From: Sian Eggington [REDACTED]
Sent: 09 August 2019 15:42
To: Sian Eggington
Subject: FW: Further Information Required on Your Ref: PP-08043885 Our Ref: LU/250/19/HH
Attachments: We sent you safe versions of your files; 527-04D 40 Parkside Avenue Proposed Elevations.pdf

DRAWING TITLE
PROPOSED FLOOR PLANS / PART
SITE LAYOUT

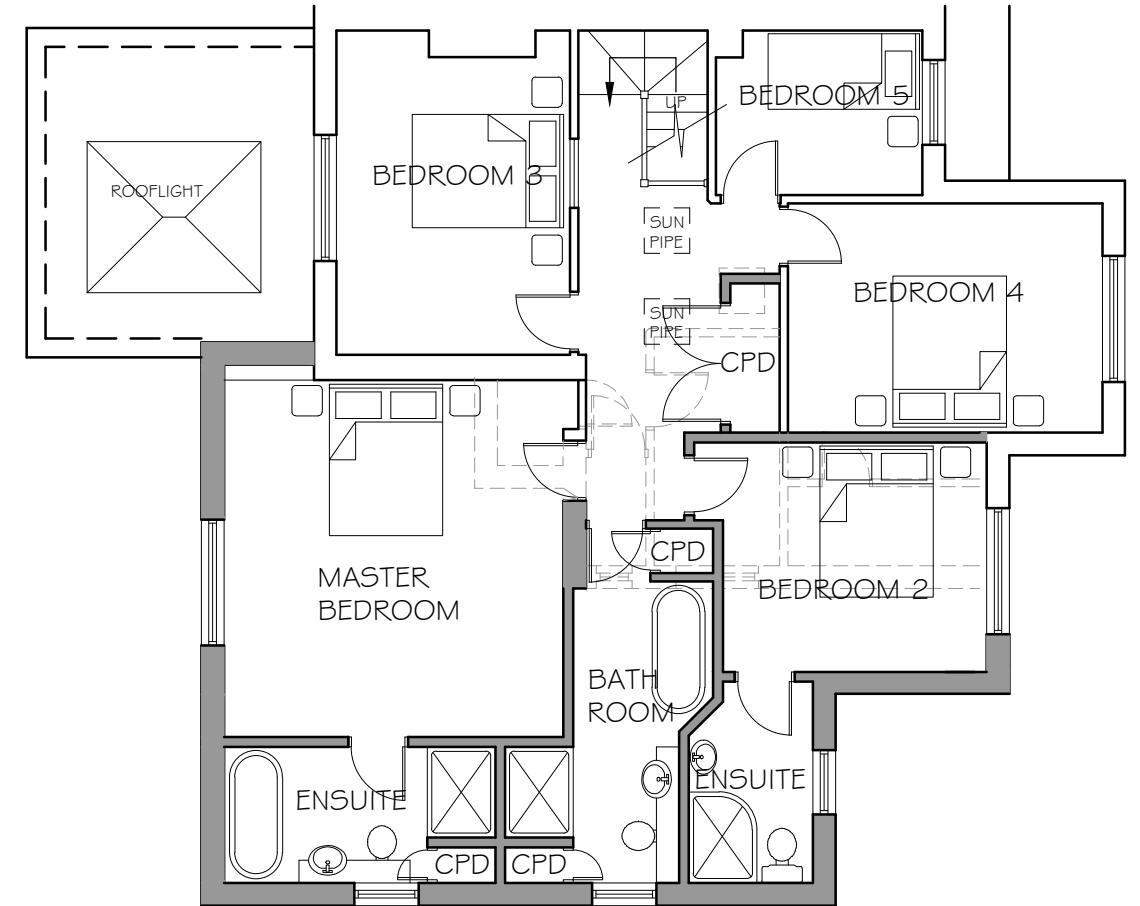
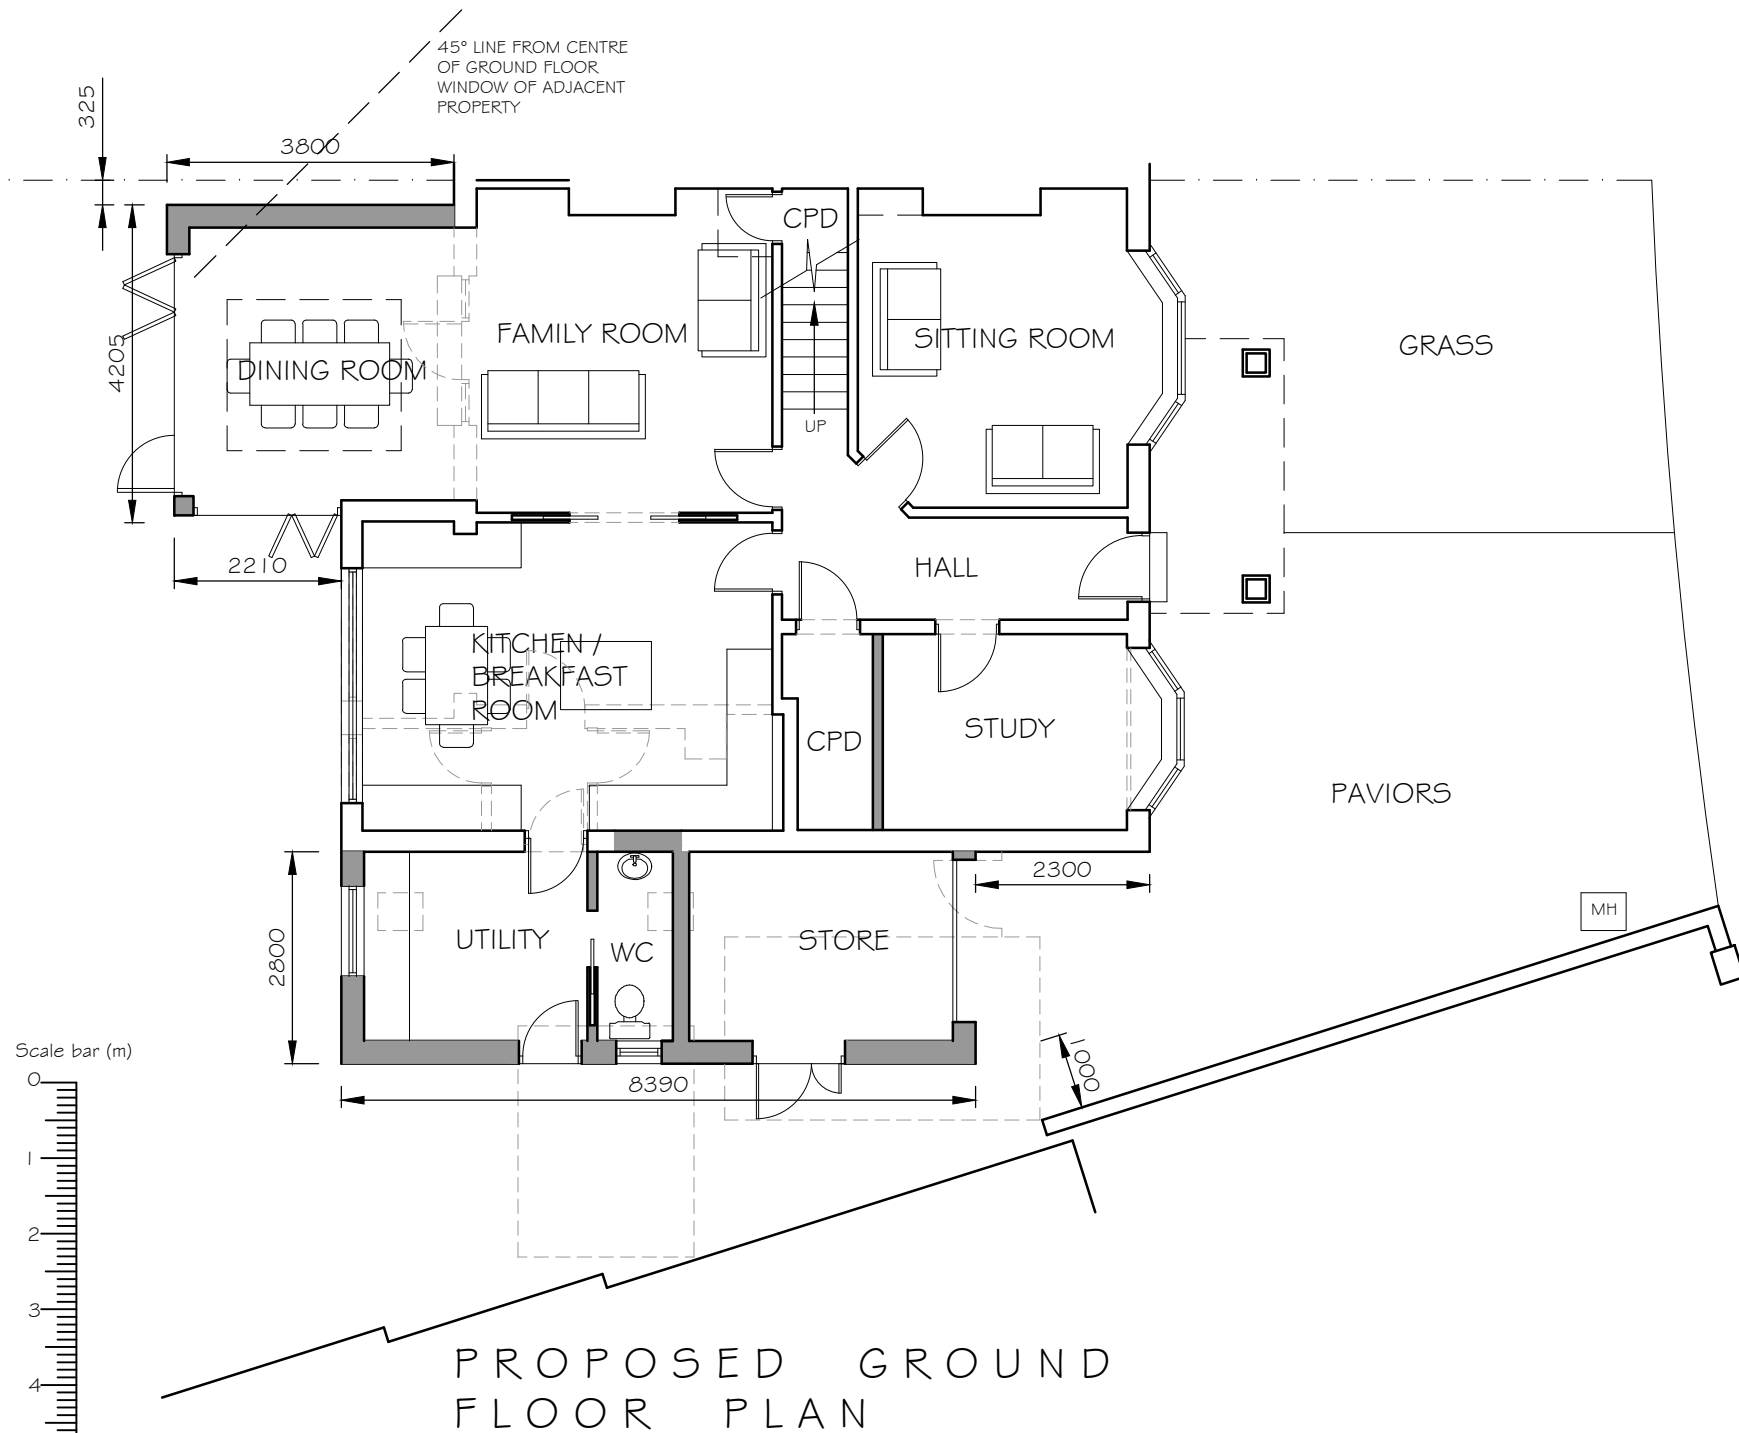
I can confirm that distances of the extension to boundaries have been shown on drawing 527-03, and I trust this will be acceptable.

DRAWING TITLE
PROPOSED ELEVATIONS

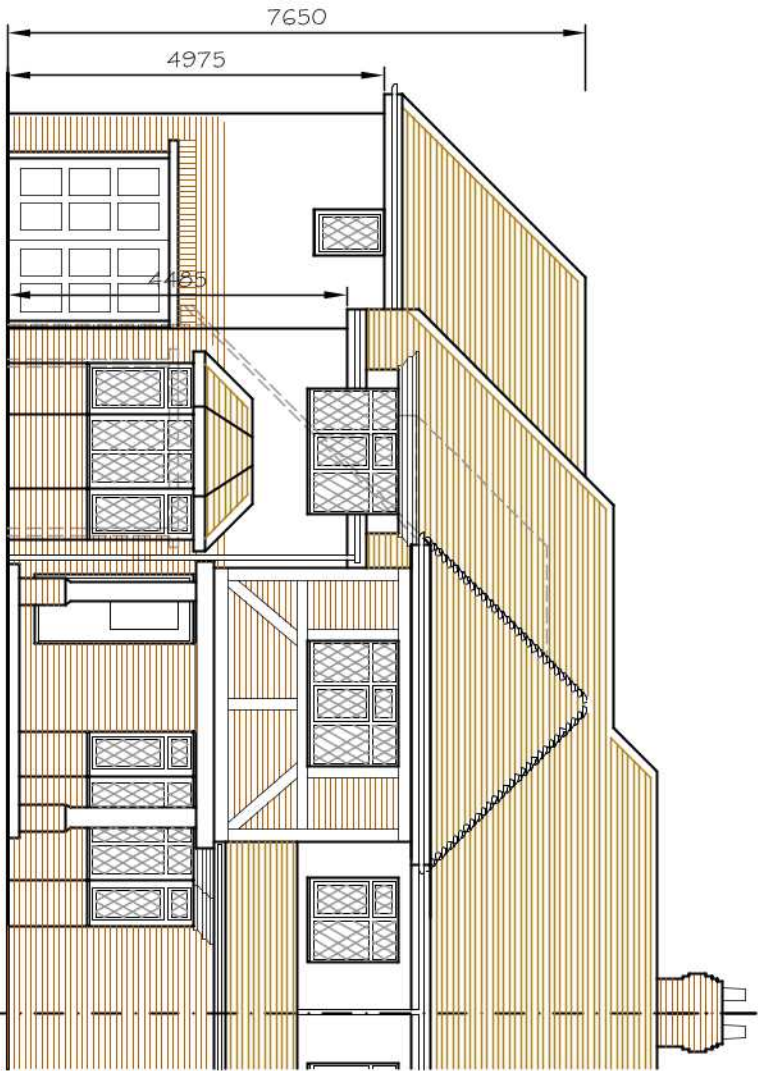
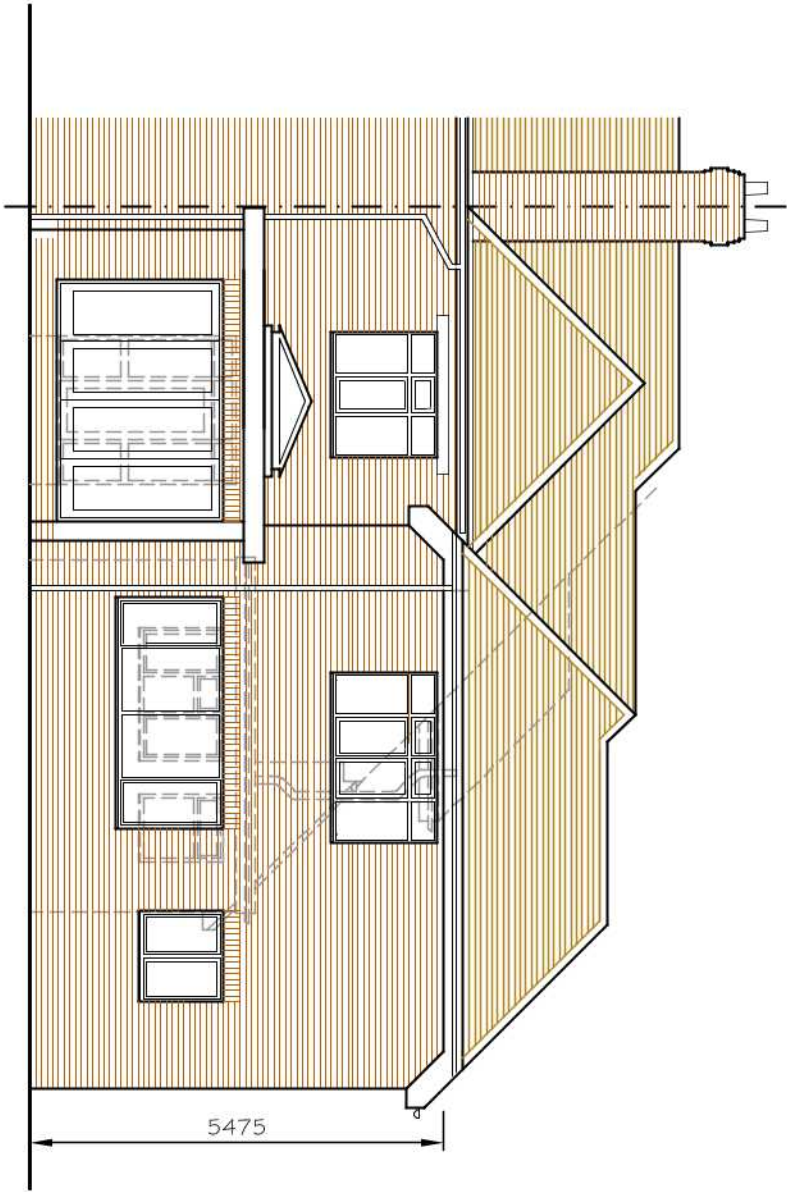
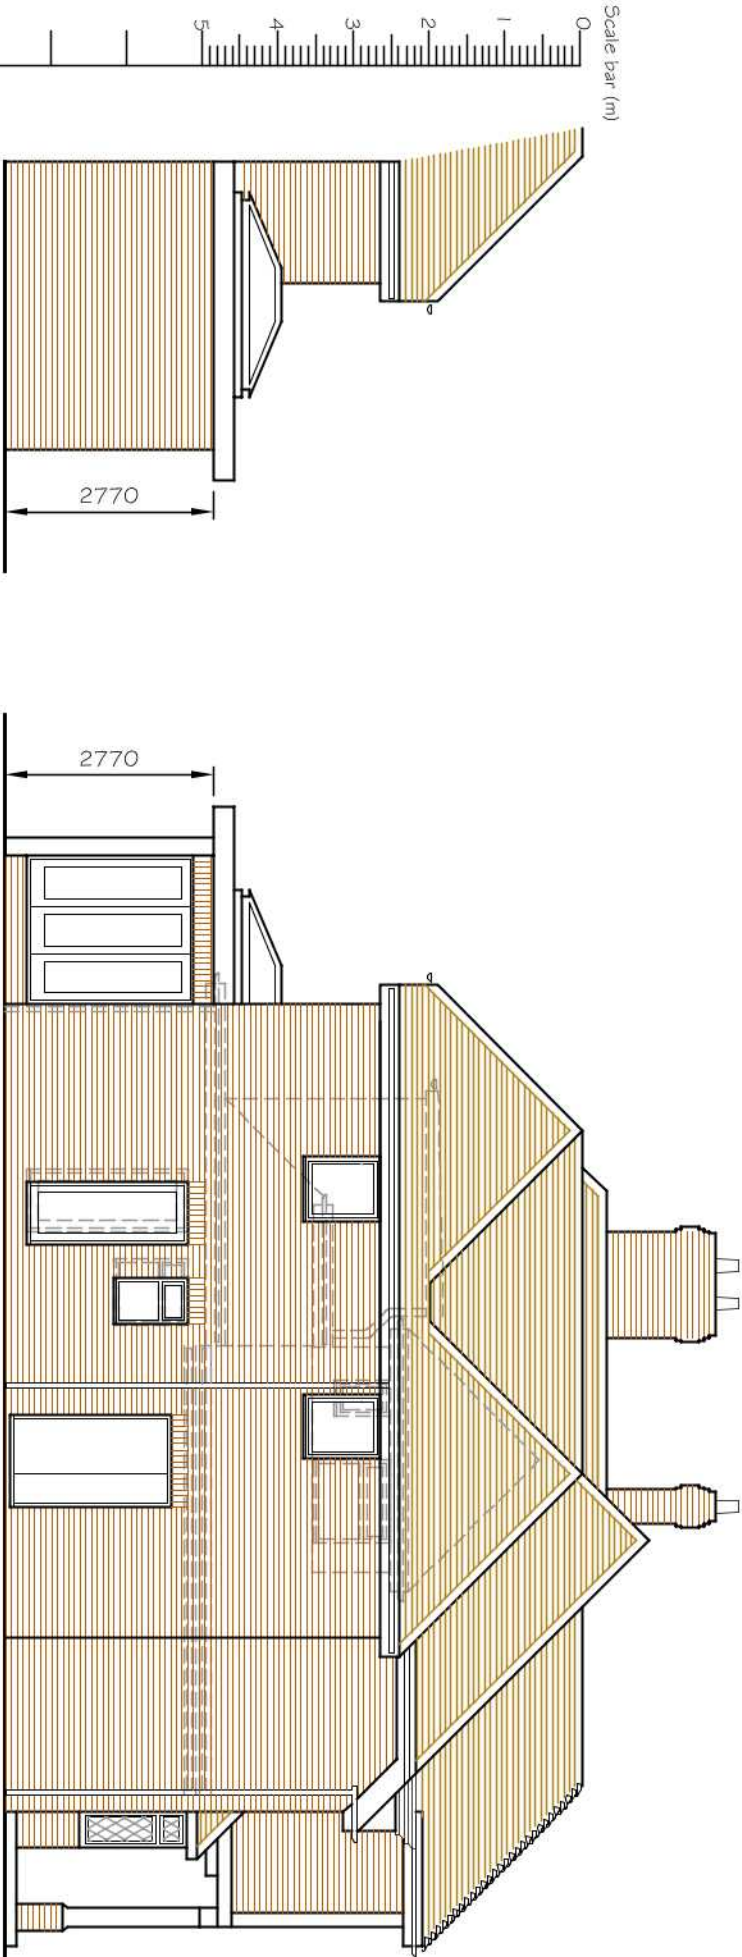
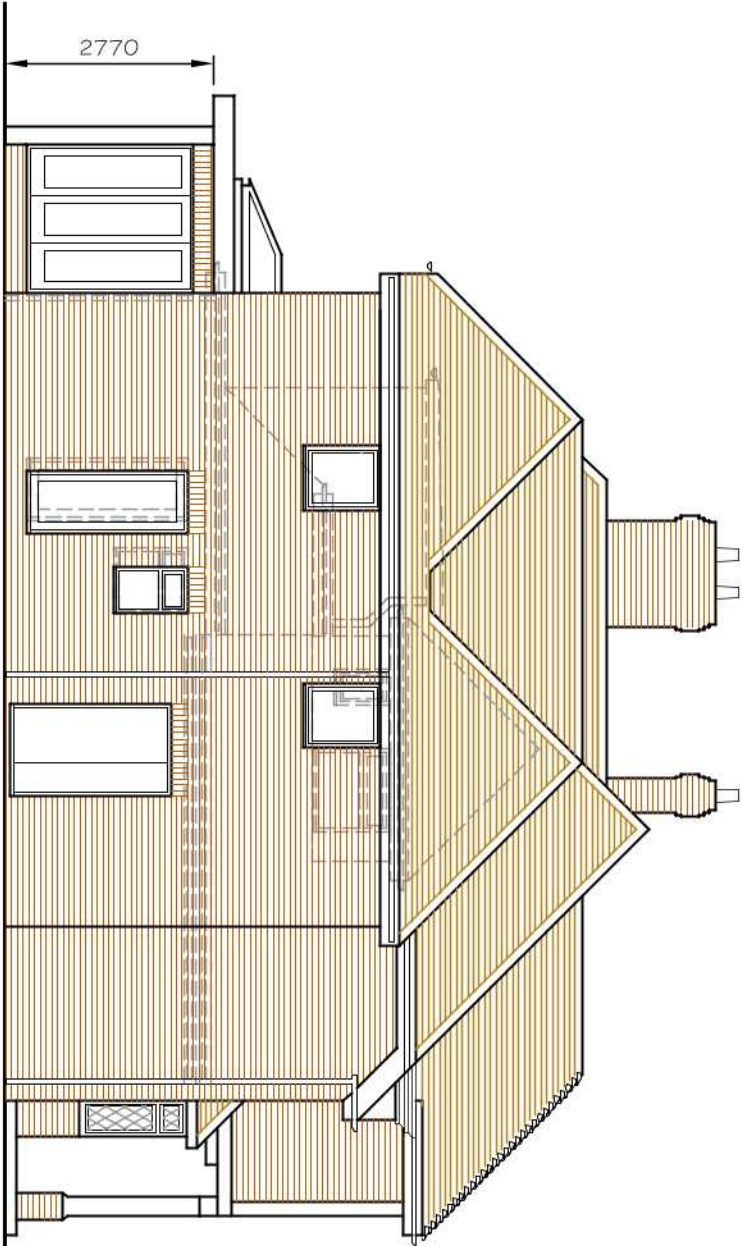
Please find attached drawing 527-04D which now includes a proposed side elevation of the north side.
